Drafted 23 October 2012

**Planning Application, Ribble Valley District
D3-12-0832 McDonald's Restaurants Ltd, RV Enterprise Park, Barrow**

SIGN 5

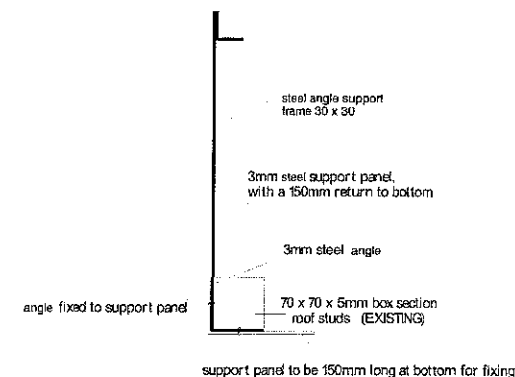
The level of illumination of the proposed signage has been considered and is not a cause for concern in terms of a potential inconvenience or nuisance for passing traffic. It would be more useful to have the lumen figure provided as candelas per square metre for ease of assessment.
